**Subject: Objection to Planning Application 2026/62/90484E
Proposed Children's Care Home – Change of use from residential to C2 residential institutions**

Location - 143 Church Lane, Gomersal
Applicant – Harmony House Retreat Ltd, Eddie Elliott-Smith
Case officer – Jennifer Booth
Consultation Ends 23rd March 2026

Proposed Ground Floor General Arrangement Plan 1:50

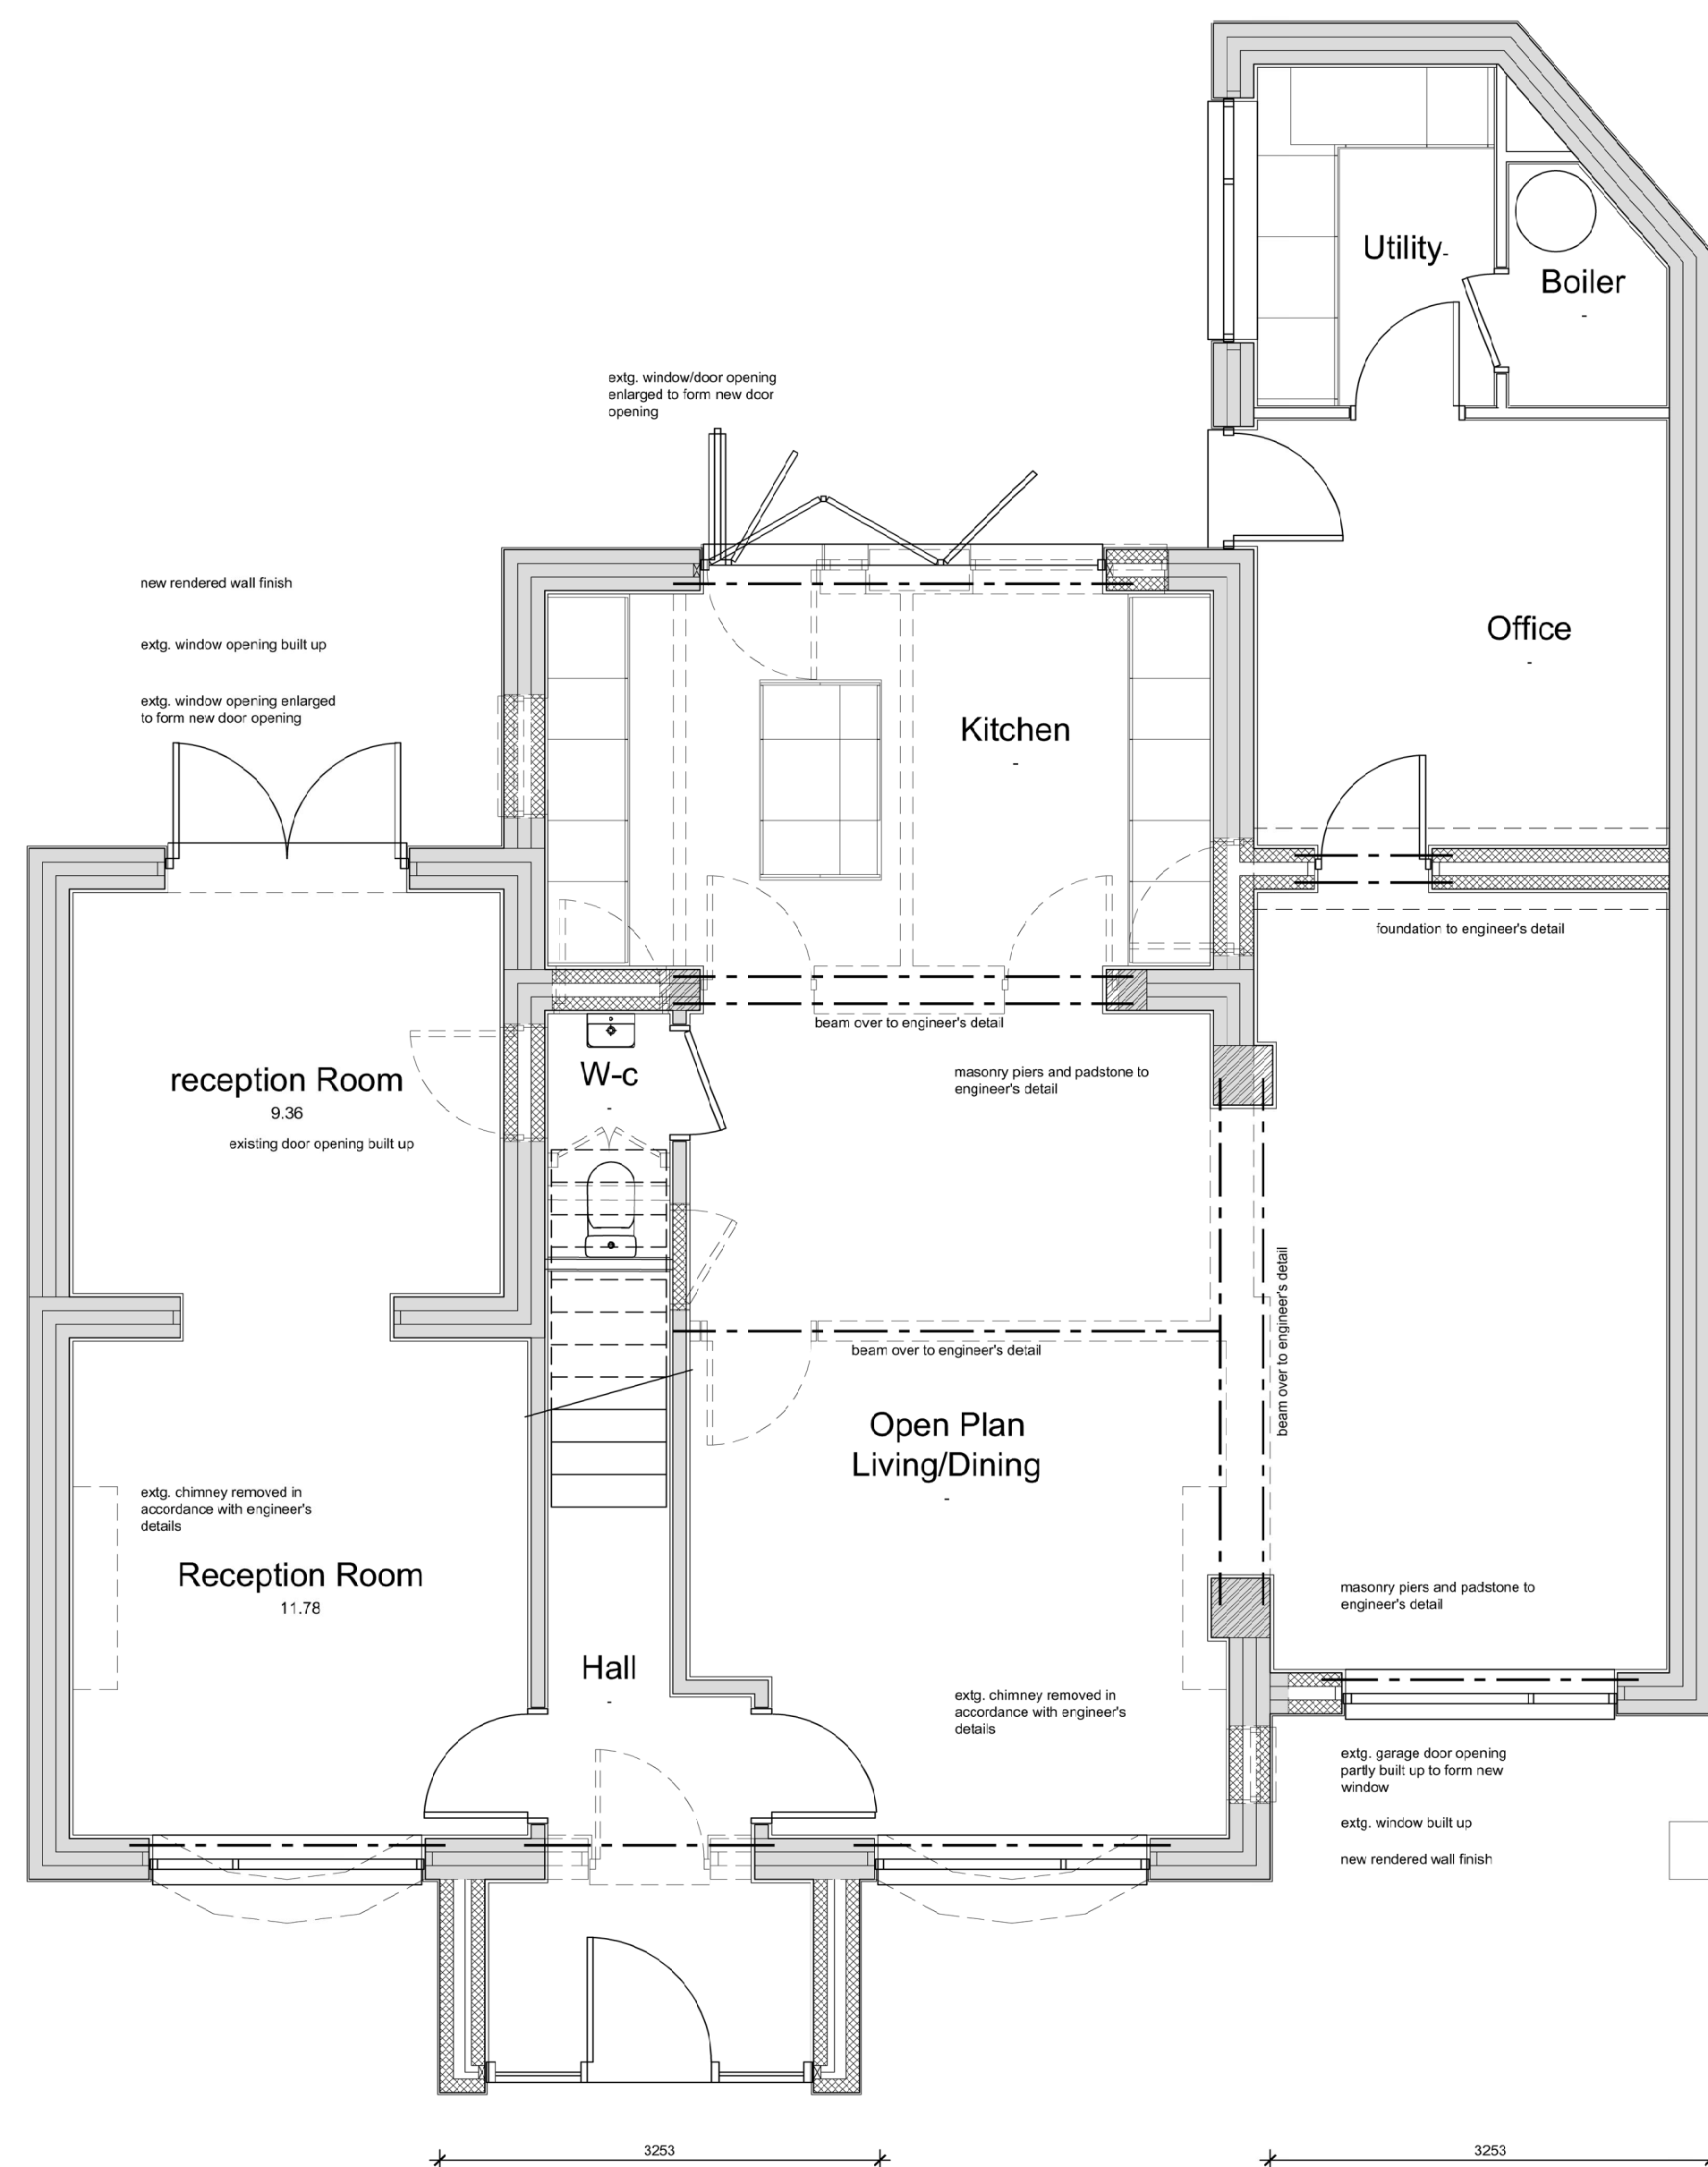
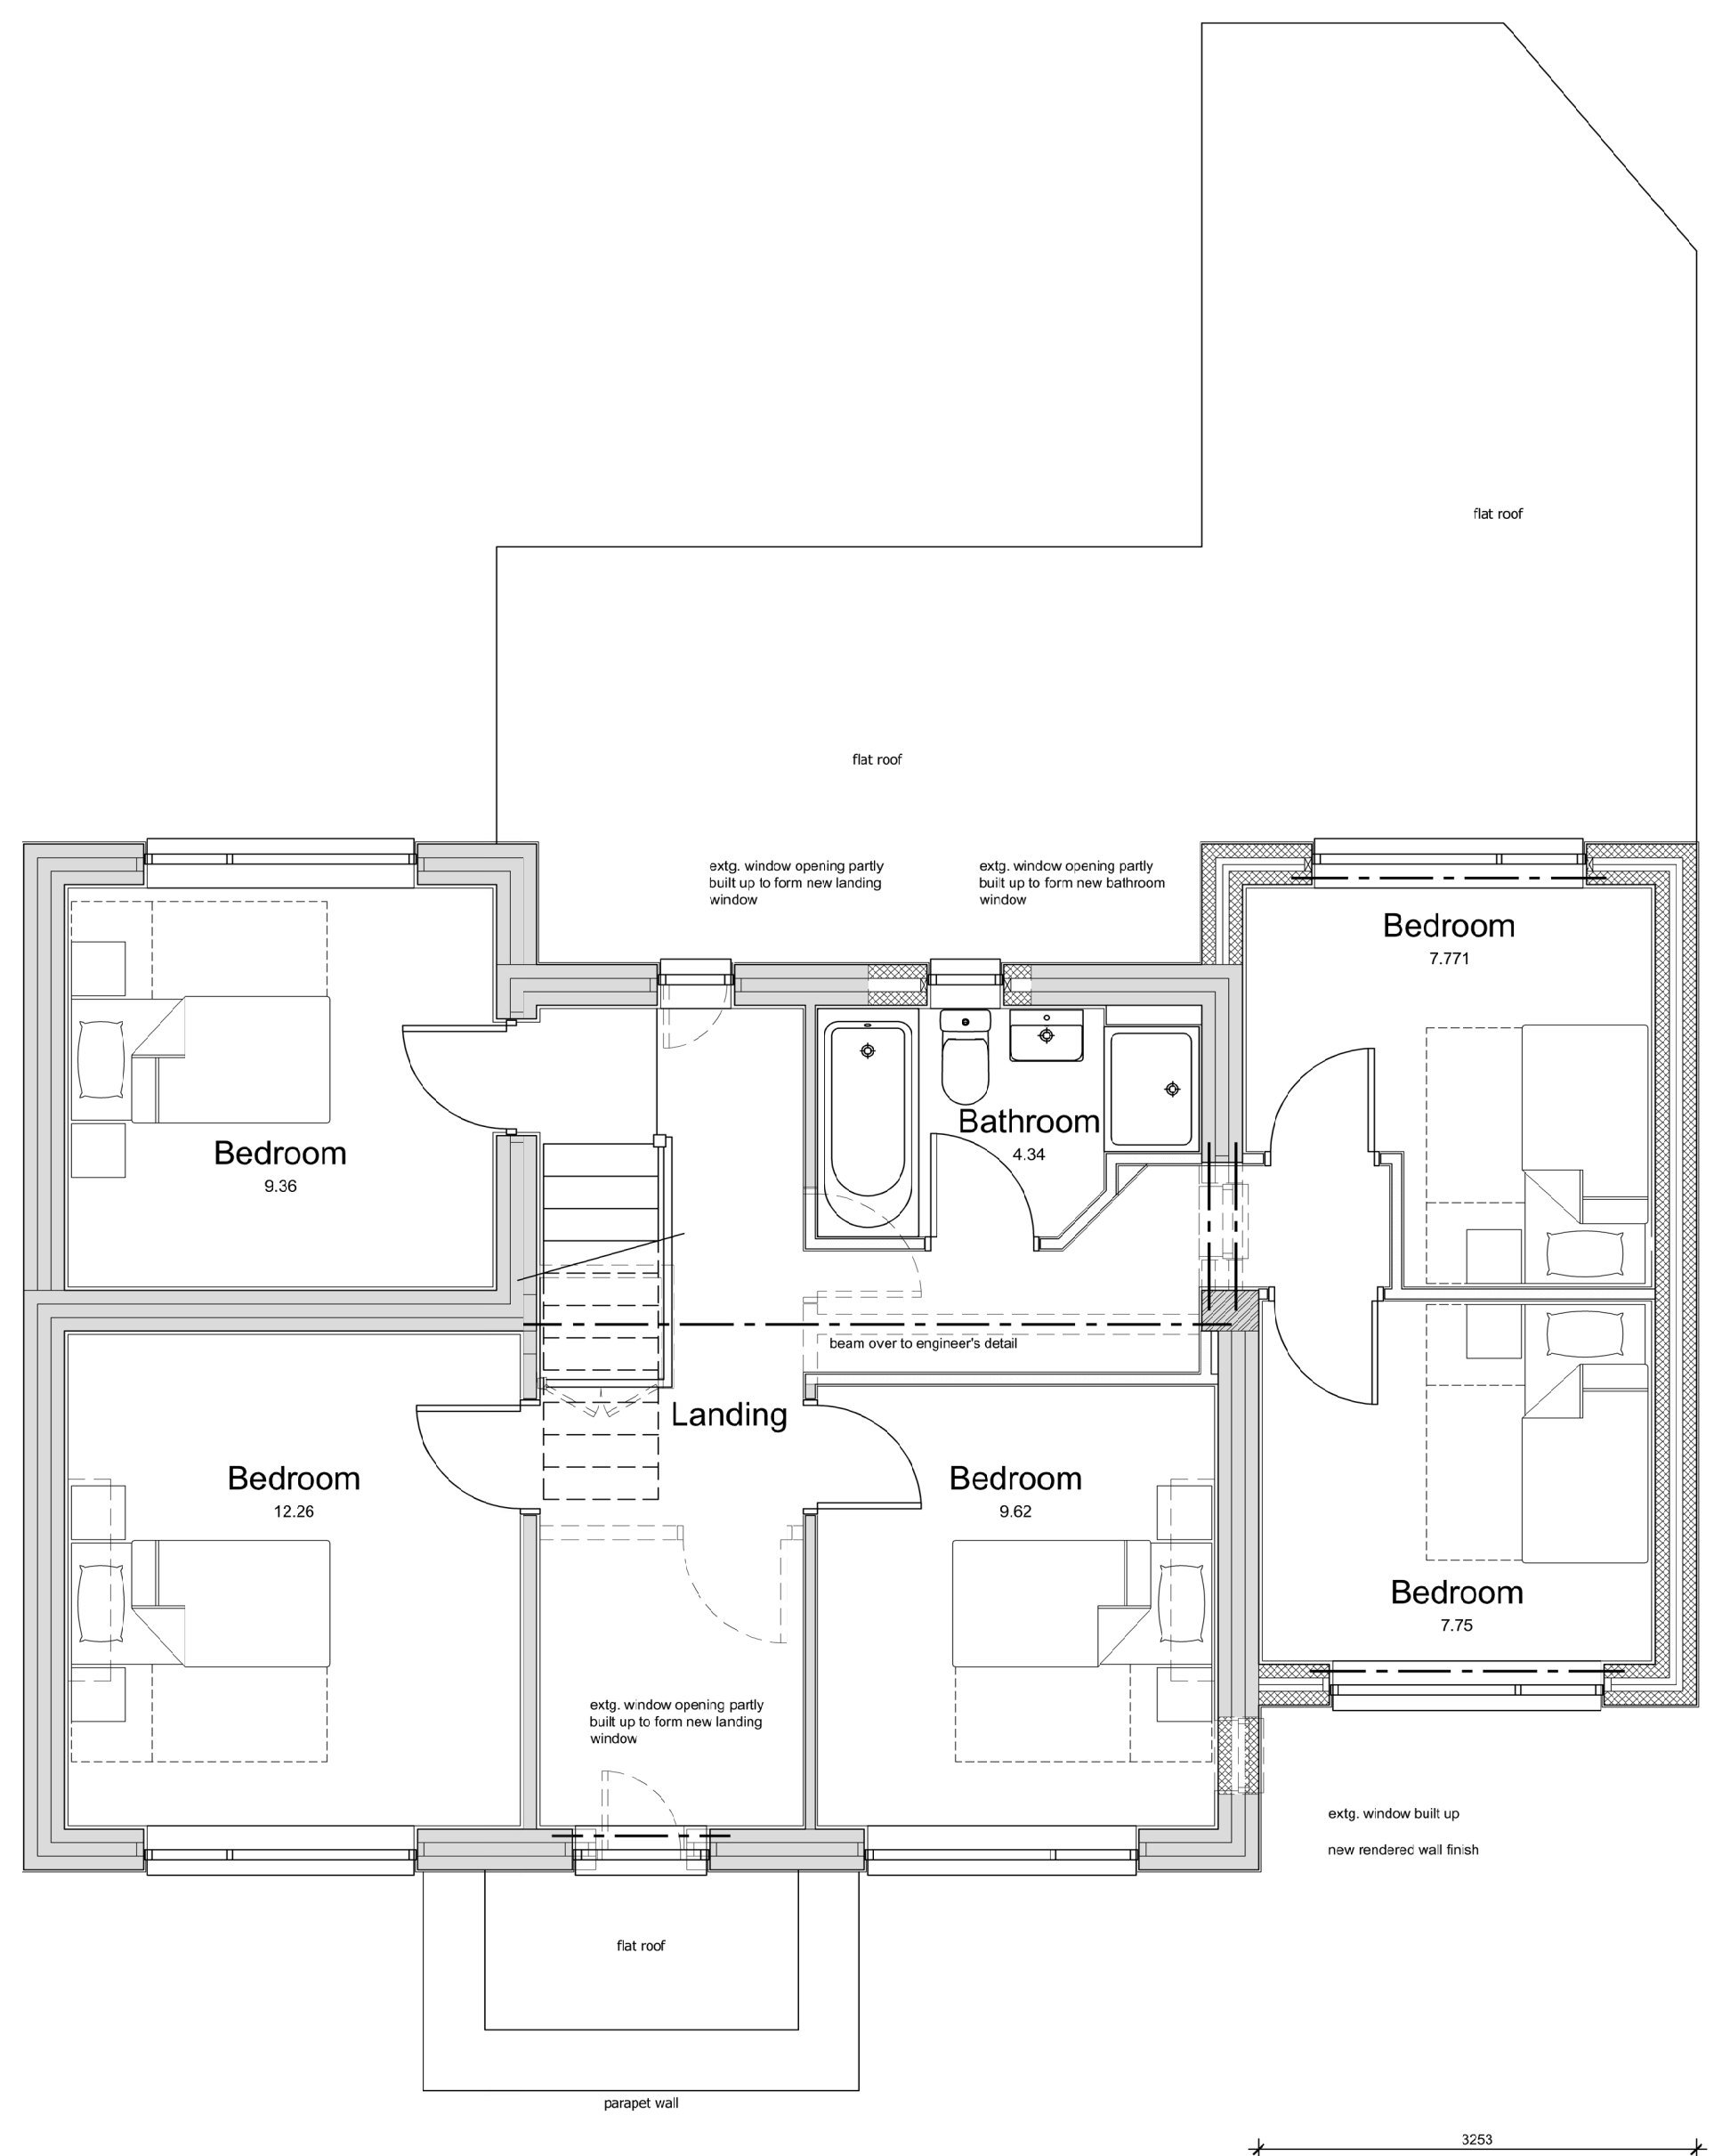
space at the location however when you take into account that the garage could have been utilised as parking but has now been converted into a room, thereby in reality not adding any further parking to the location. The application provides only two on-site parking spaces. This is inadequate for the needs of the home and will ultimately lead to inappropriate parking in the locality causing a nuisance to residents, increasing congestion and obstructing visibility at nearby junctions as has already been experienced just in the development phase.

Proposed Site Layout 1:100

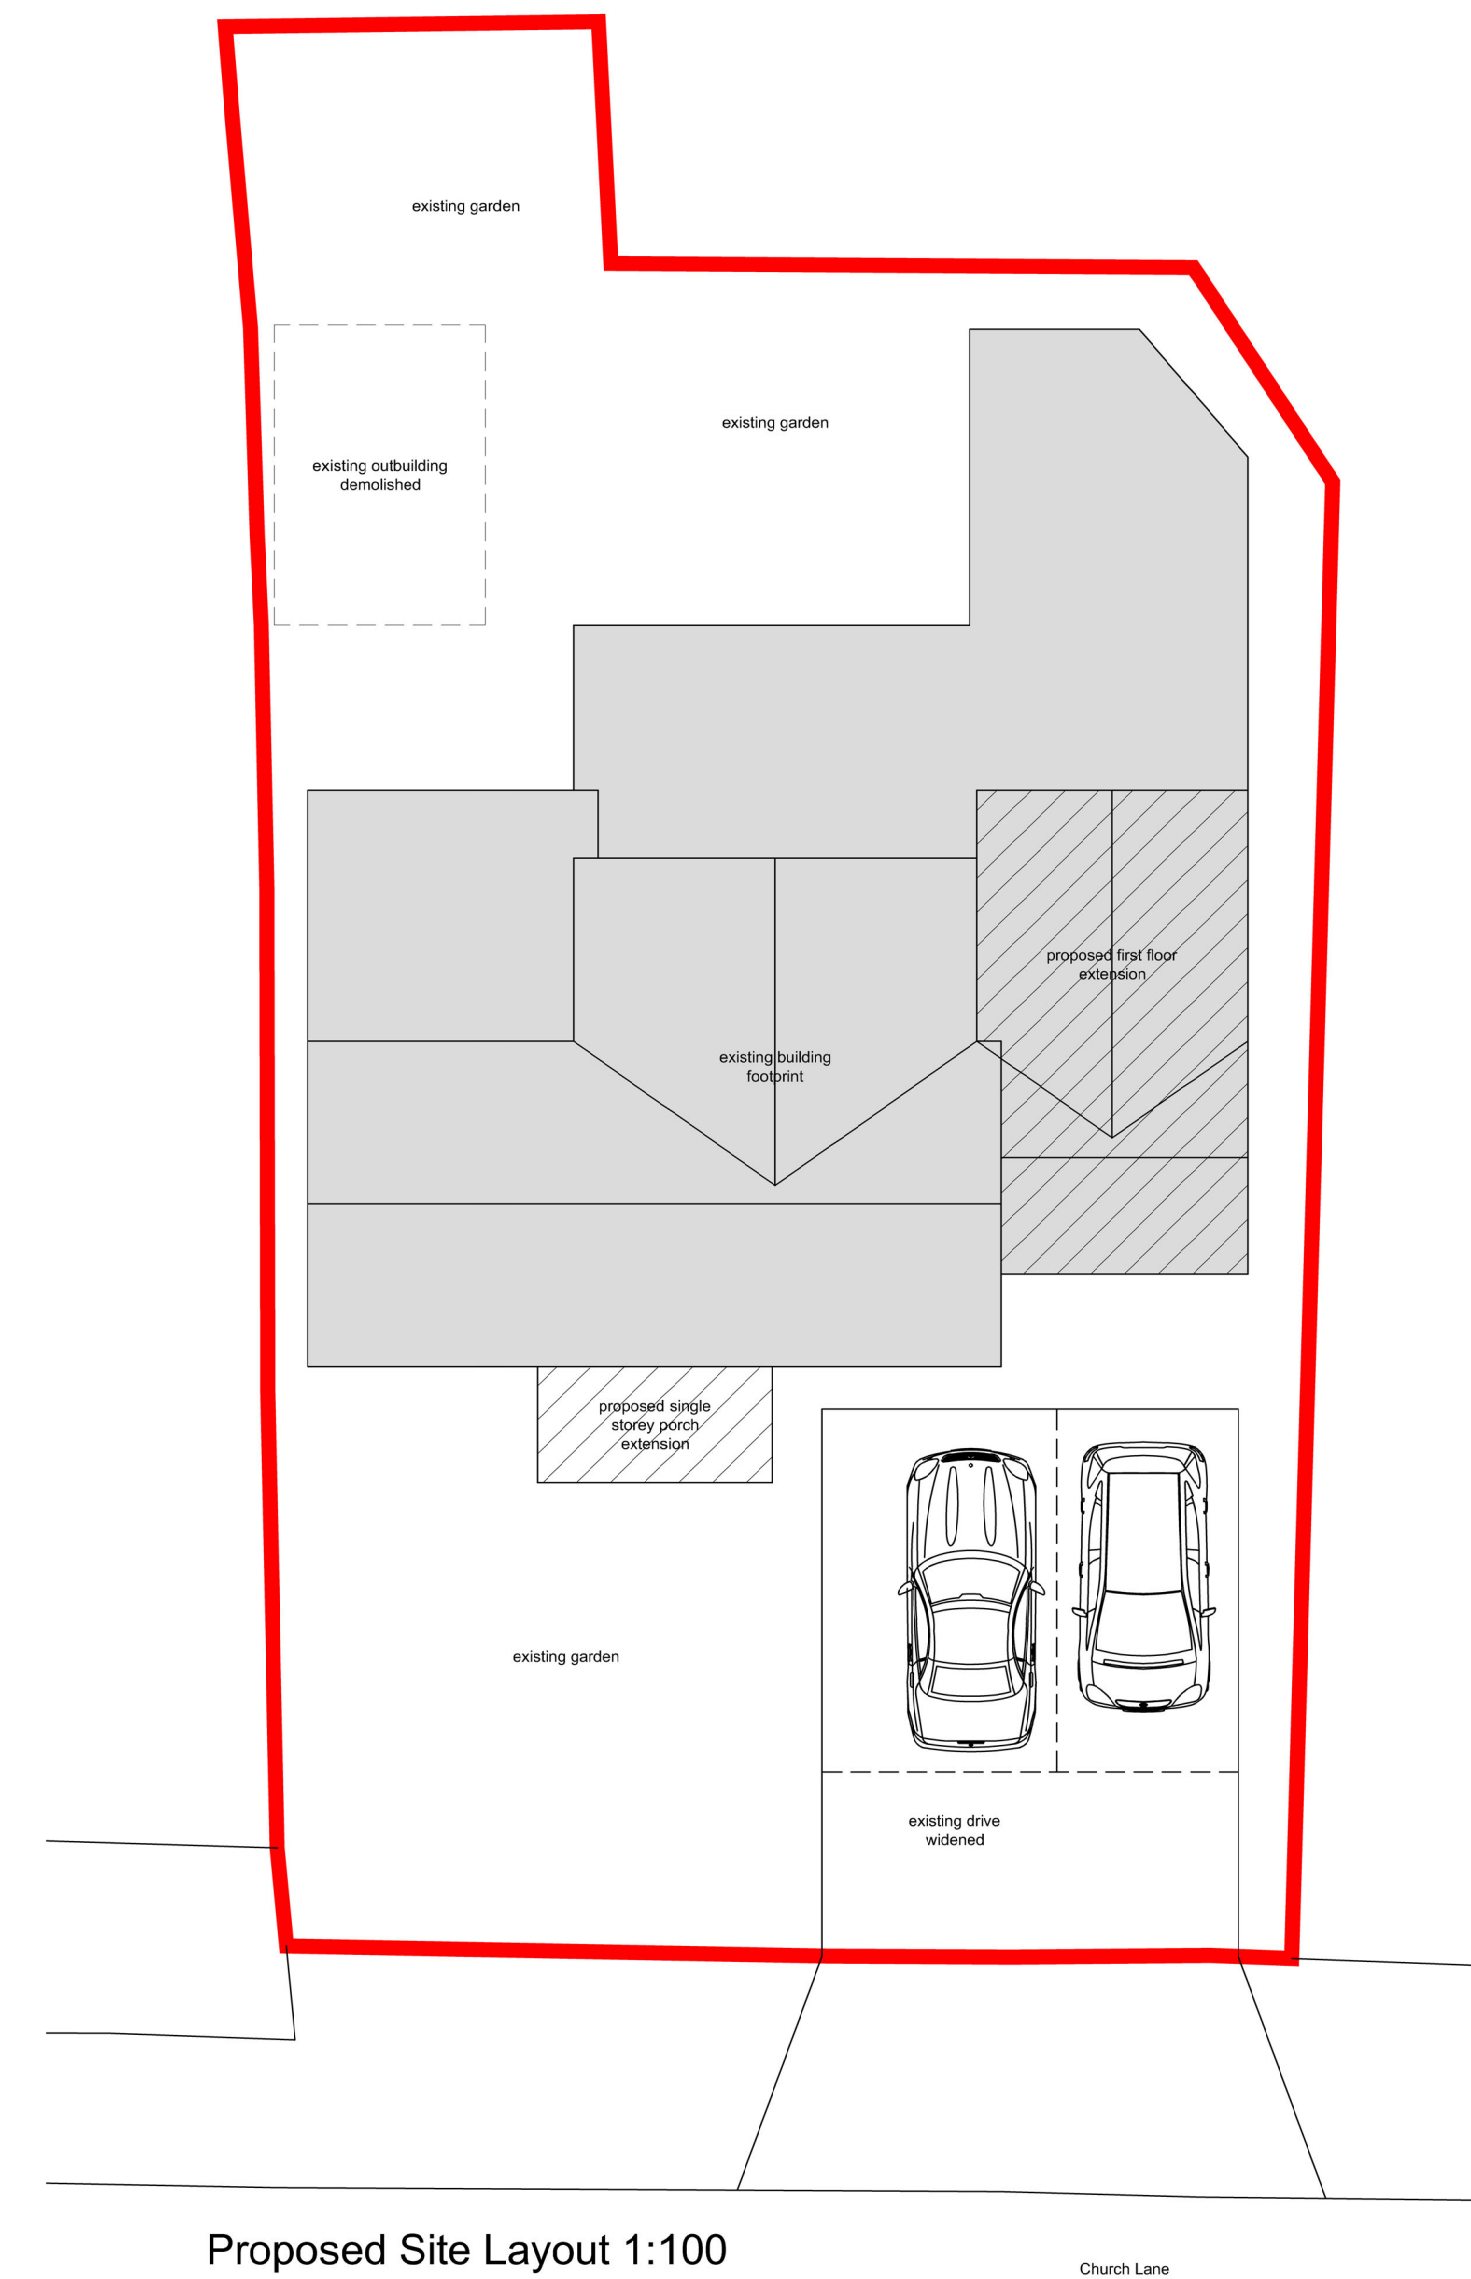
There is insufficient on-site parking to facilitate the comings and goings of staff across multiple shifts, visiting families, social workers, therapists, cleaners and other professionals such as the emergency services. The proposal states that it has added one more parking

The property is located within a greenbelt area. I would ask the planning officer to consider whether or not this is a case of over development of the original footprint of the property. There is very little outdoor space if you take into account the outside area that will remain

should the development go ahead; it should be questioned whether this is suitable to accommodate the young people who may take up residence. The plans states that there will be gate entrance/exit access control, this will further reduce garden/outdoor space along with the allocated parking spaces.
